Permitting and Inspections Department  
Michael A. Russell, MS, Director

February 14, 2018

**CBL: 082 B024001**  
**Located at: 15 DEVONSHIRE ST**

**Inspection Violations**

# 15 DEVONSHIRE

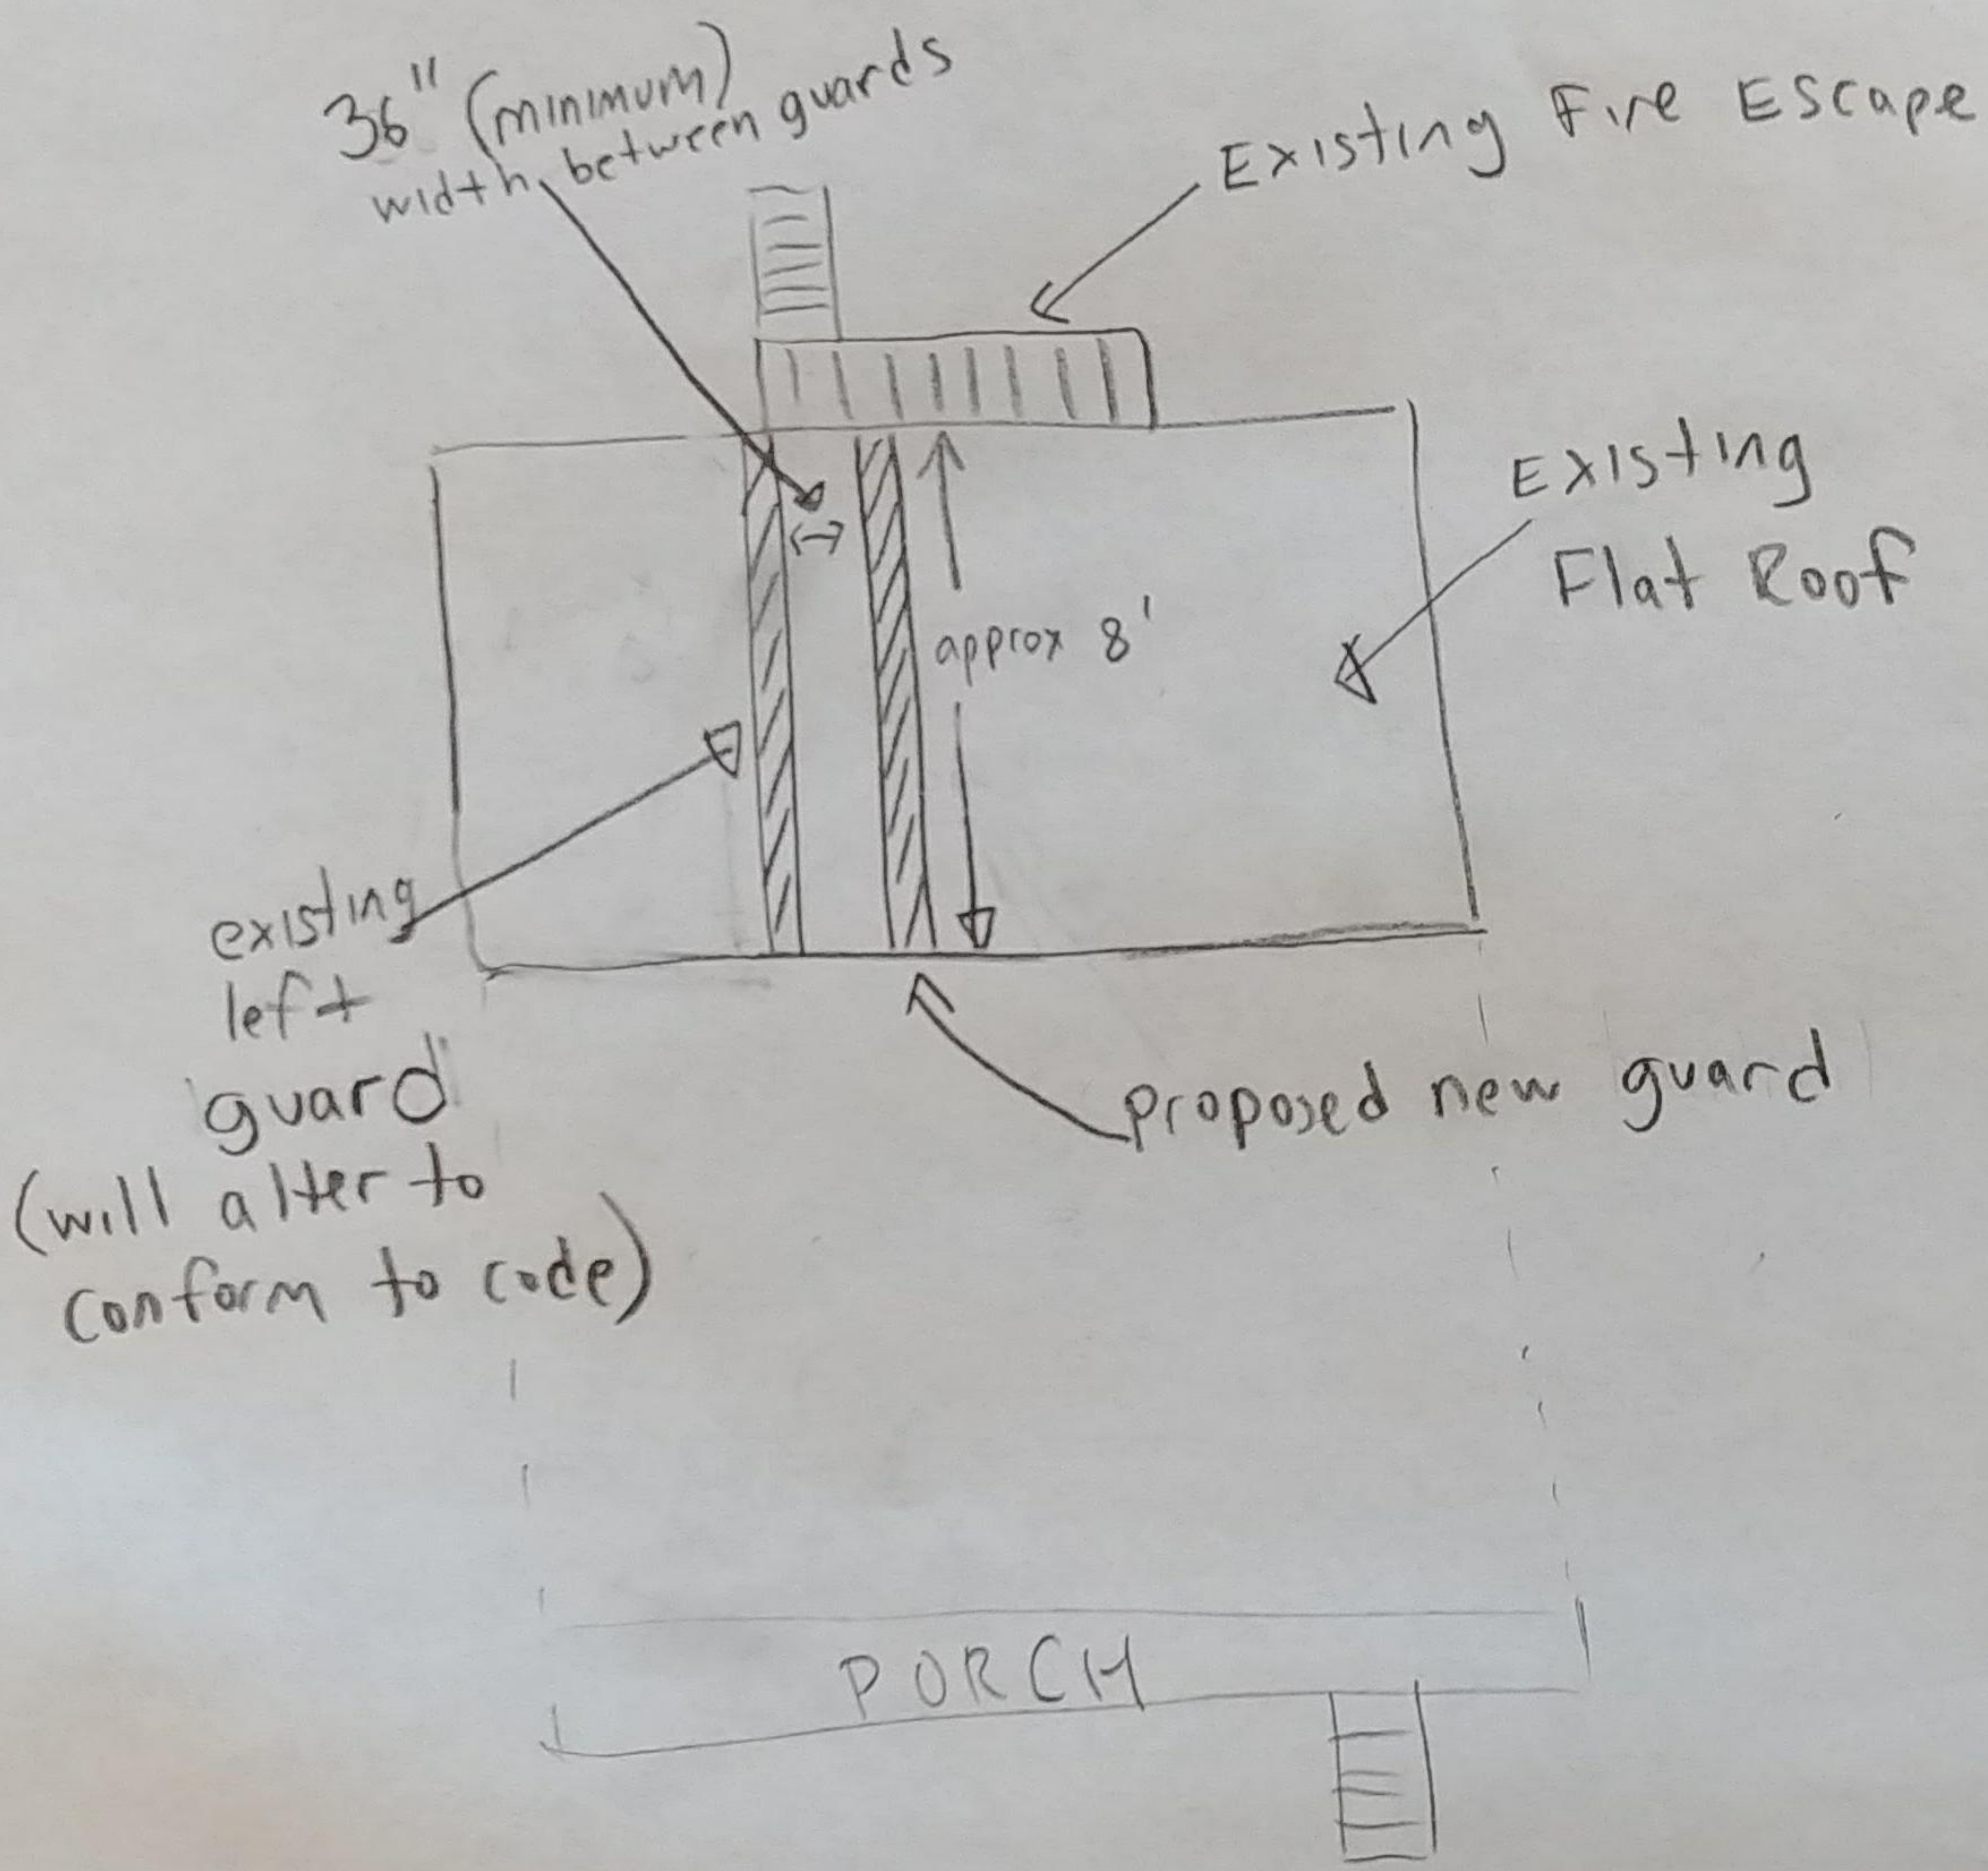
5) 211	Exterior				
<b>Violation:</b>	OTHER				
<b>Notes:</b>	NFPA 101 7.2.8.5.1- All fire escape stairs have walls or guards and handrails on both sides in accordance with 7.2.2.4. A building permit is required to be applied for with the Permitting and Inspections Department within 30 days.				
<b>Comments:</b>	Field Inspection 2/13/18- Multiple Fire doors required. 3 unit doors and one basement door required to be 1 hour fire rated. Plan of action for fire doors required within 30 days. Unit doors are required to self close and self latch. Under stairs needs to be repaired. Bedroom for top floor unit requires to have a hardwired smoke alarm. Railing required for fire exit for the top floor unit on roof. Owner needs to apply for a building permit for the railing within 30 days of the date of notice.
